15879

Conditions of development consent for the Sydney Metro Martin Place Station Precinct SSD 9326 – South Site

Condition B5, B6 and B7 discharge request #2 – Design excellence and design integrity review

Level 08 Plan

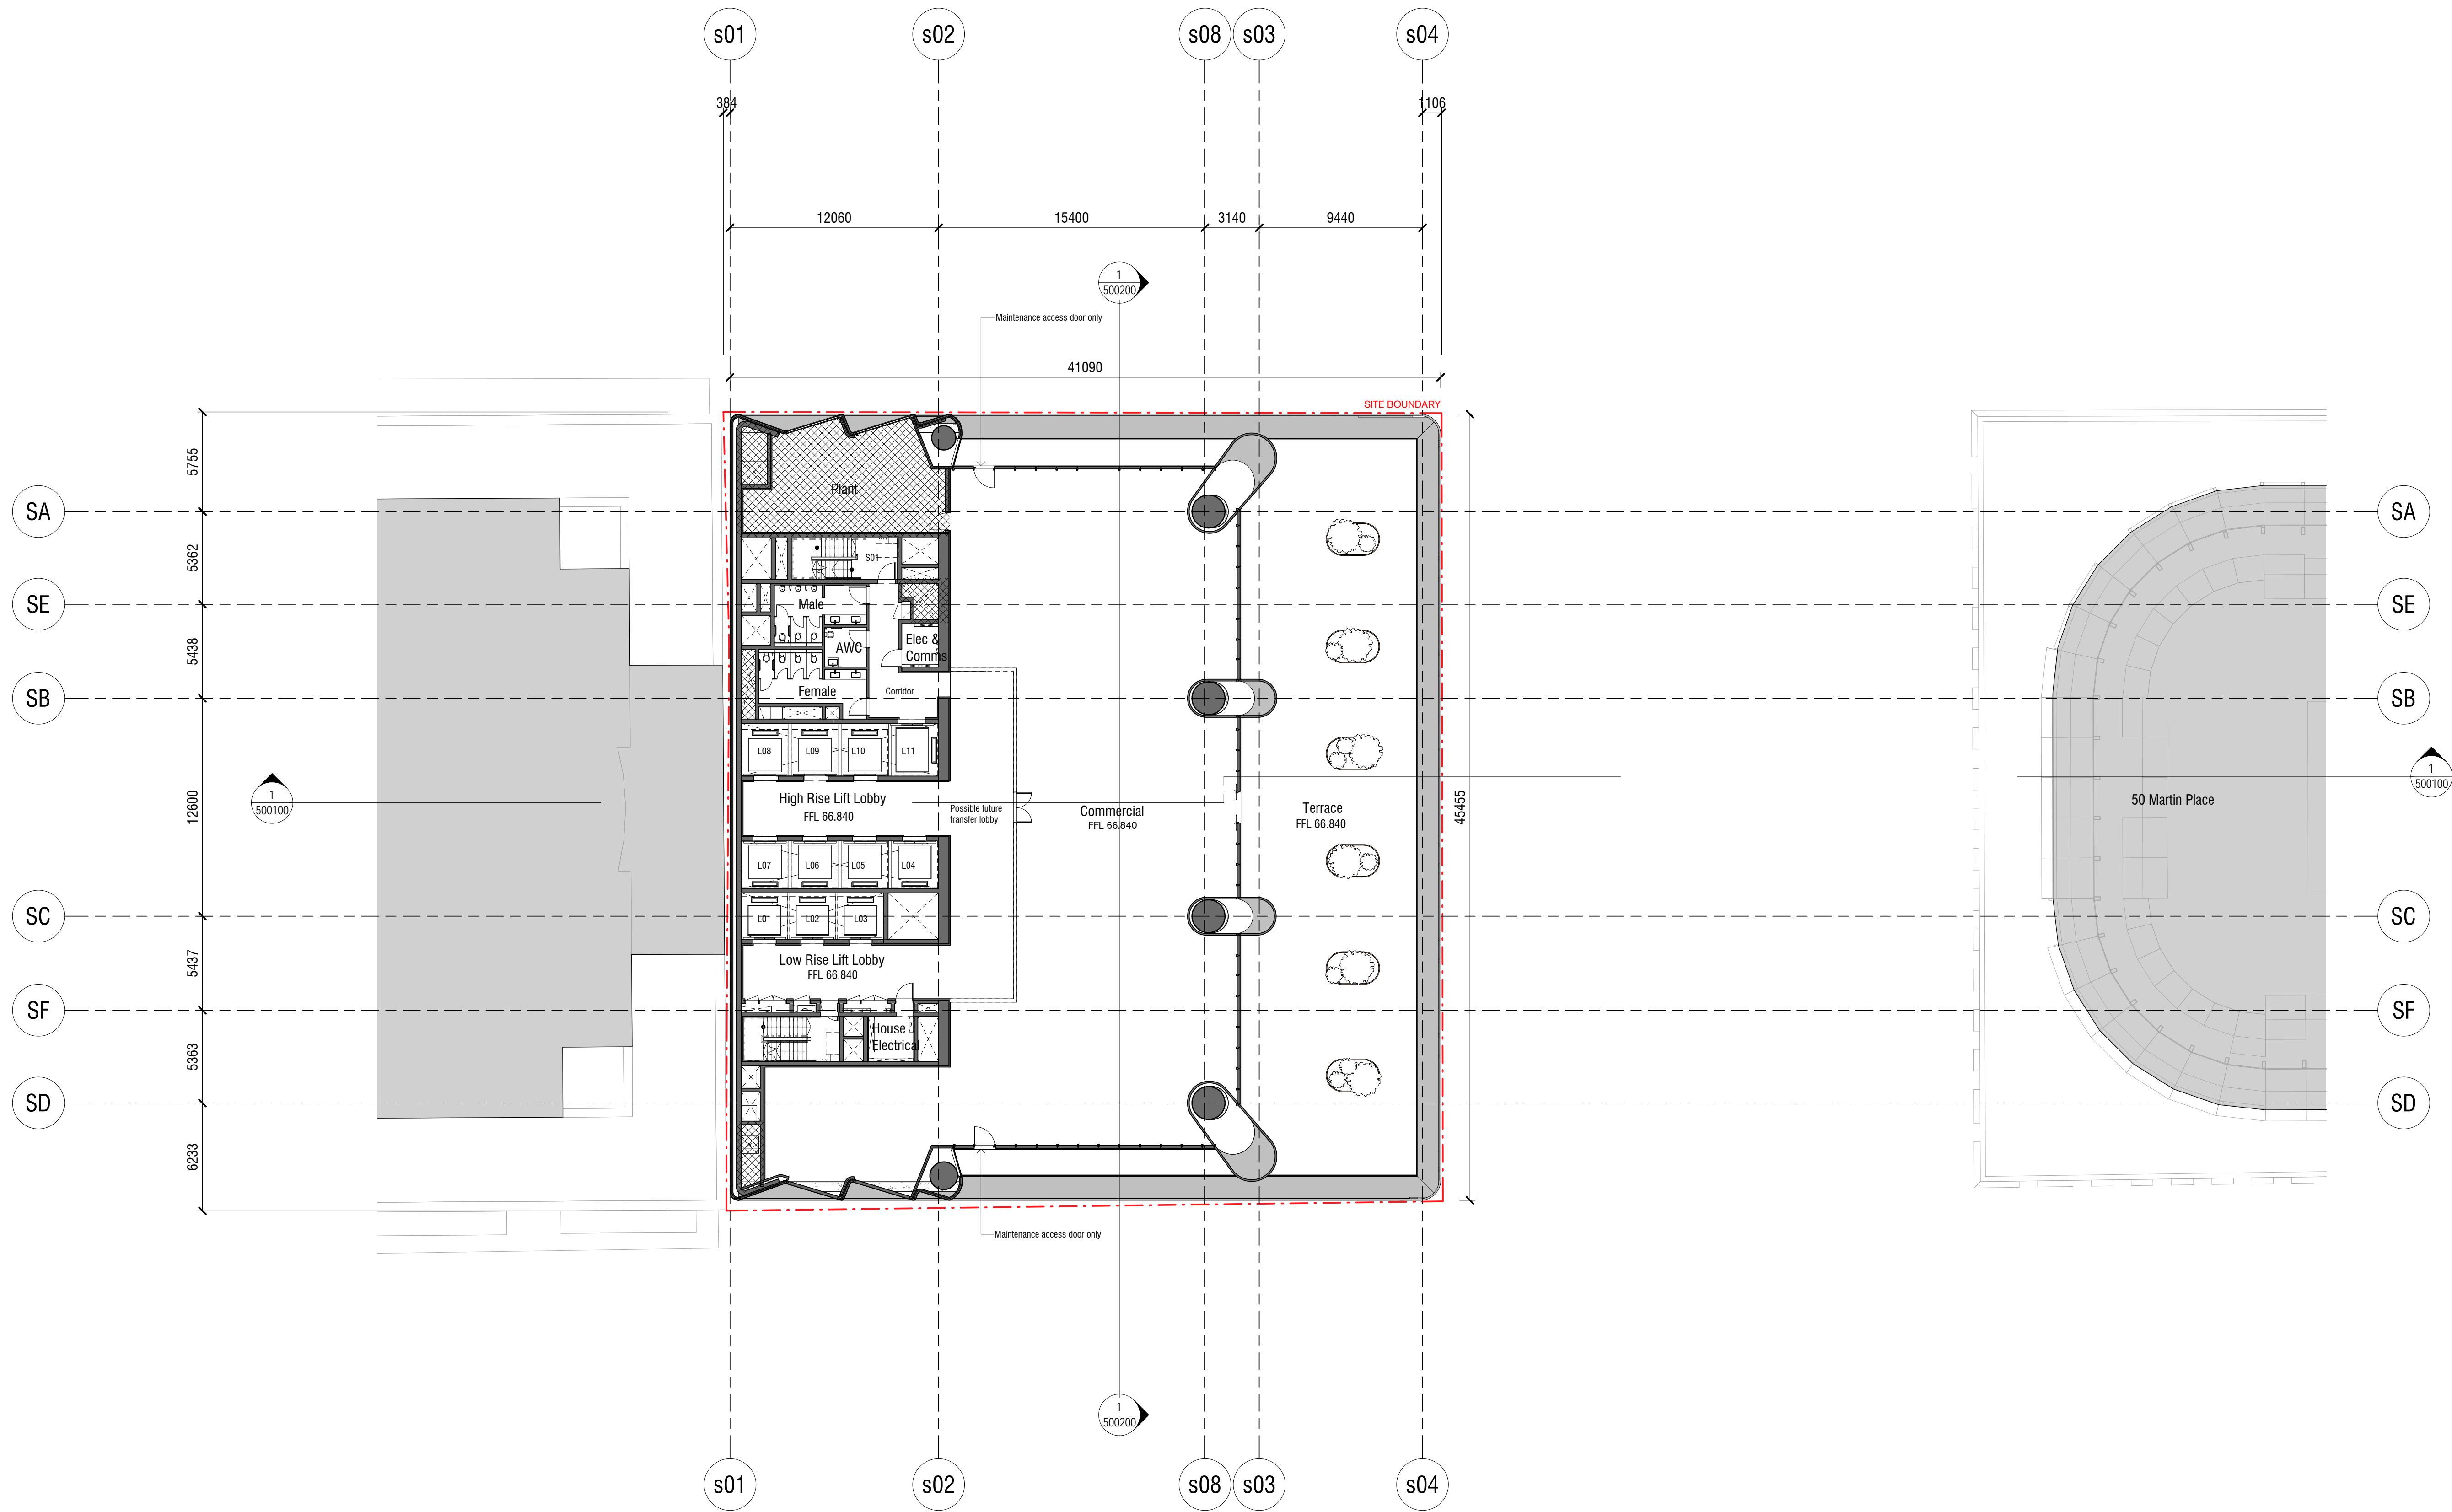
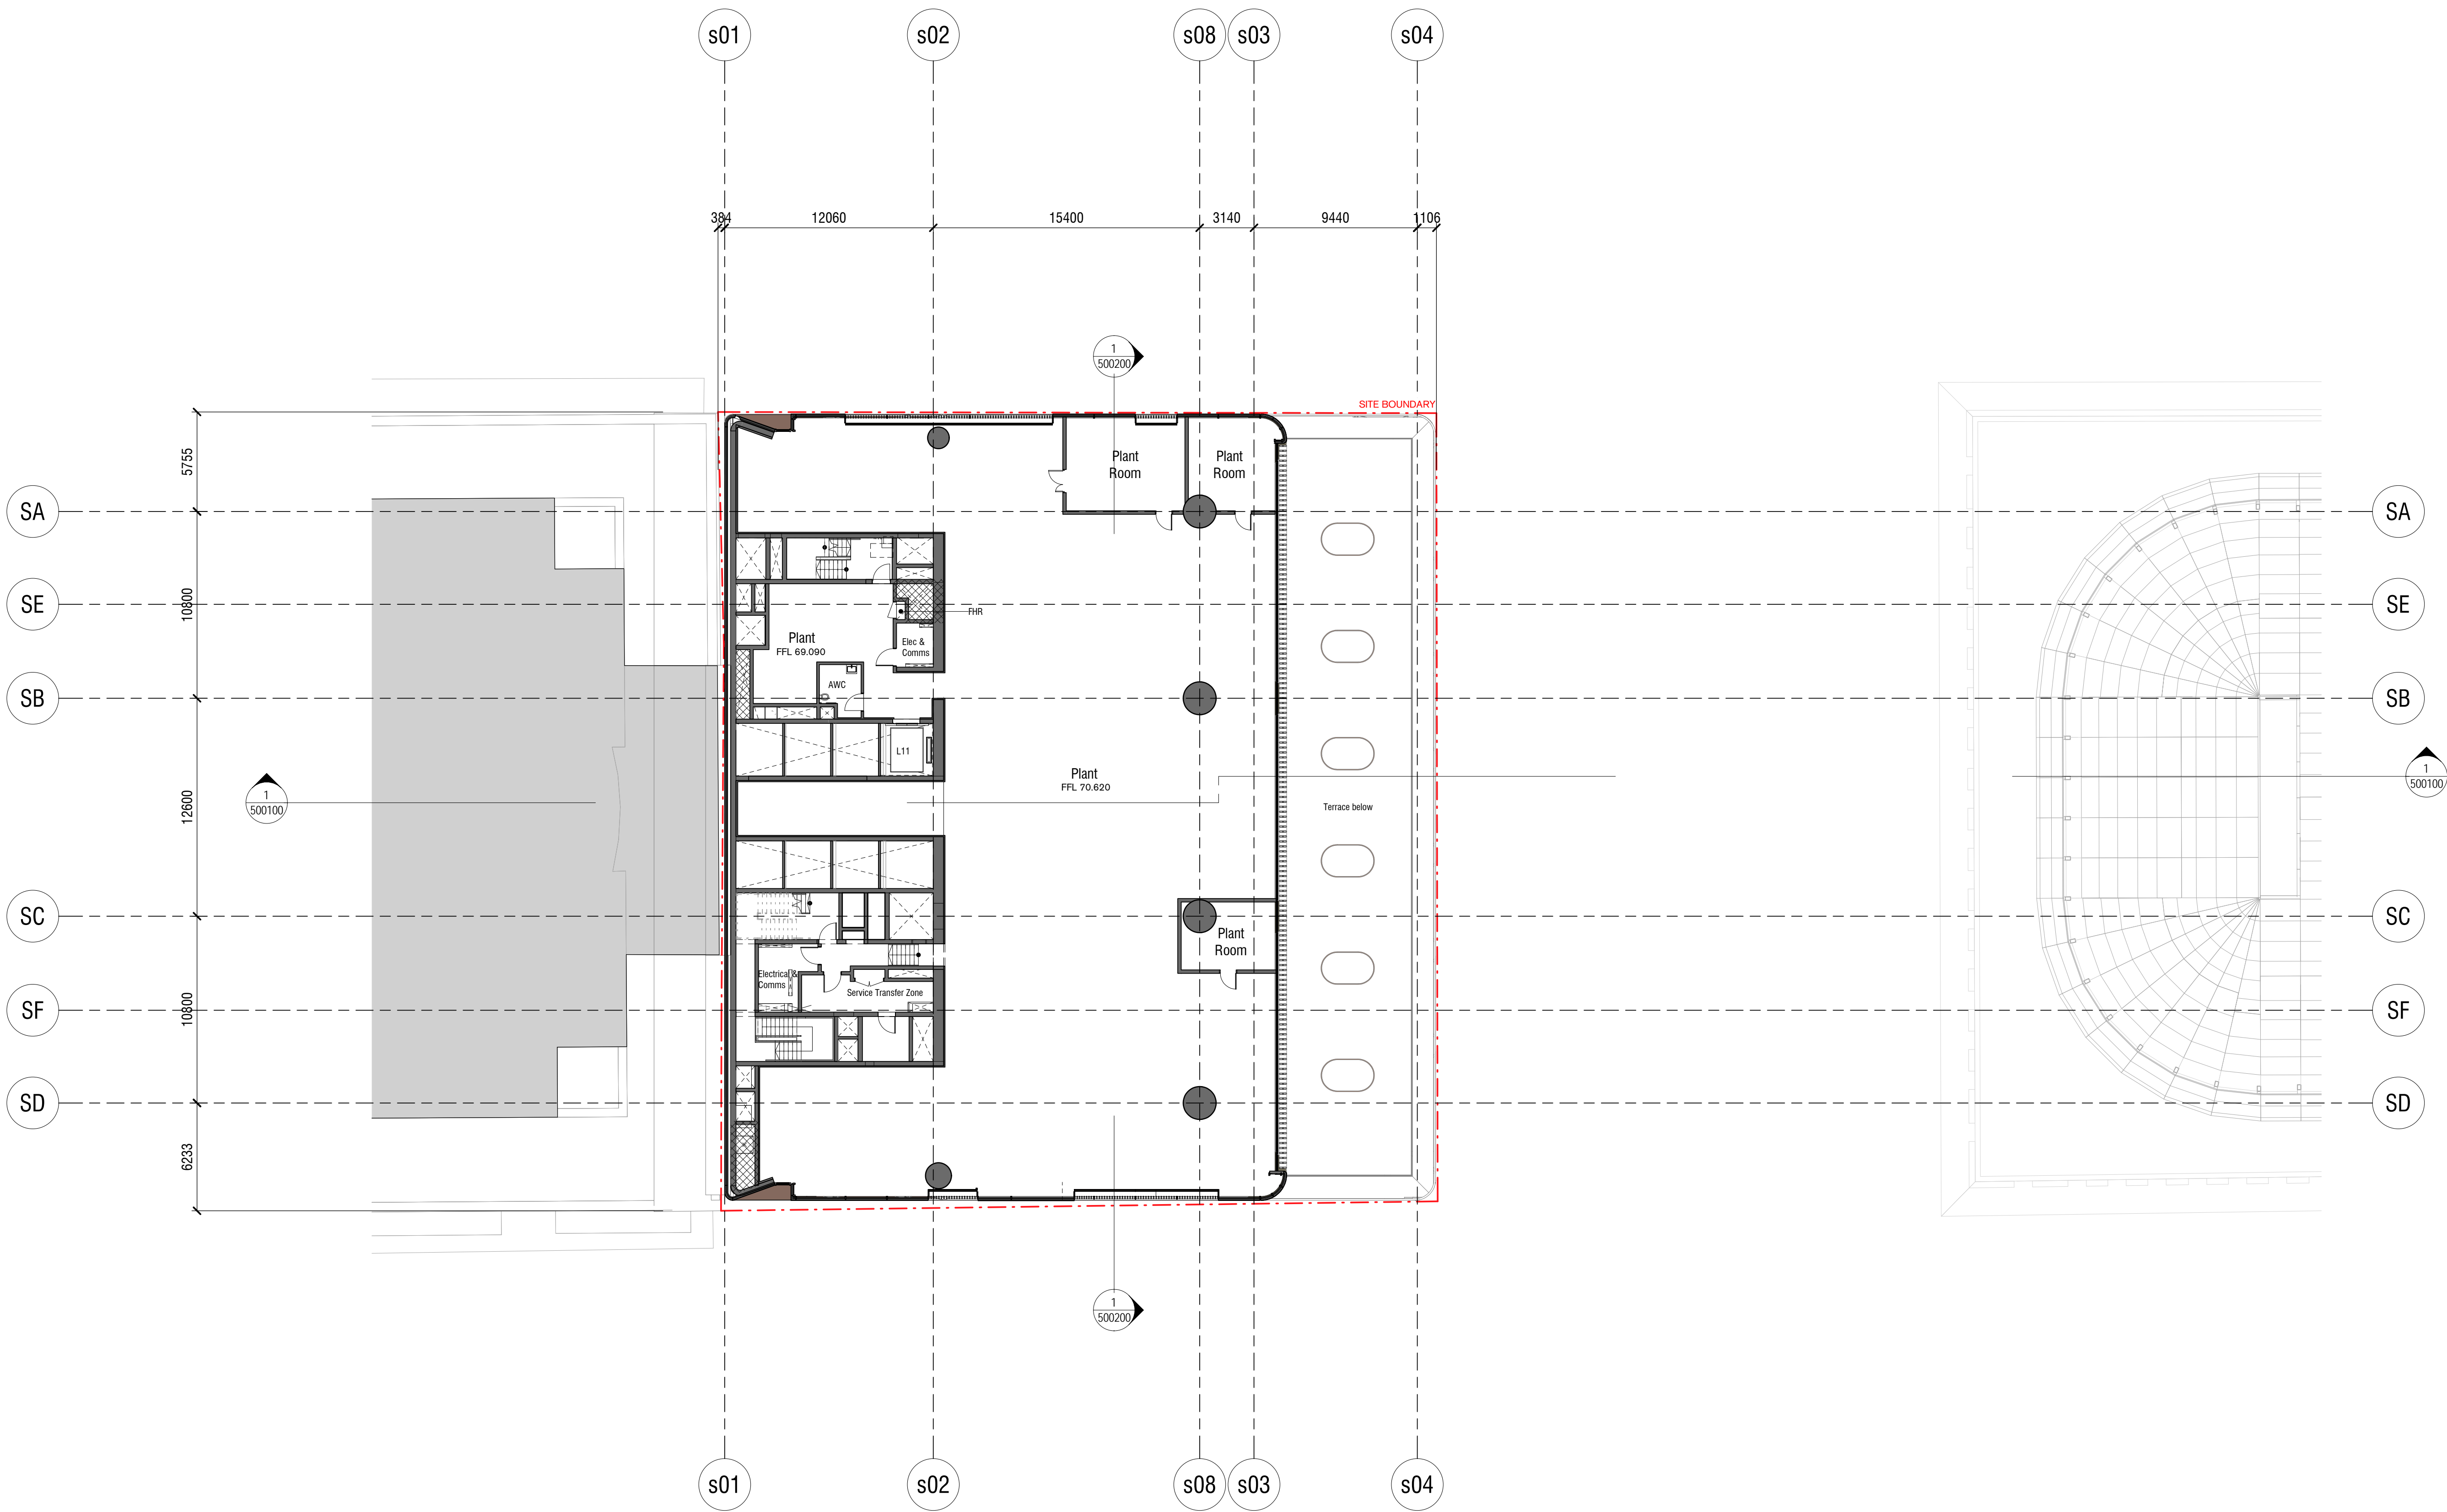
Appendix reference	Design change	OSD DRP engagement approach
App A Reference 2	Internal core changes (Level 8-27), door swing changes, handrails added on Level 9 and changes to direction of the stairs on Level 28 and 29, fixed ladder added on Level 29, in order to achieve BCA compliance.	OSD DRP review is not considered necessary on the basis that the proposed changes are wholly internal and will not result in any changes to the exterior of the building.
App A Reference 3	Services coordination: Plant room layout changes on Level 28 and riser and plenum reconfiguration on Levels 10-12.	OSD DRP review is not considered necessary on the basis that the proposed changes are wholly internal and will not result in any changes to the exterior of the building.
App A Reference 4	Design development: Structural wall thickening on Level 7, door relocation on Level 27 and structural detailing added to drawings, façade structure coordinated and bracing detail added for structural support of external cladding on Level 29	OSD DRP review is not considered necessary on the basis that the proposed changes are wholly internal and will not result in any changes to the exterior of the building.
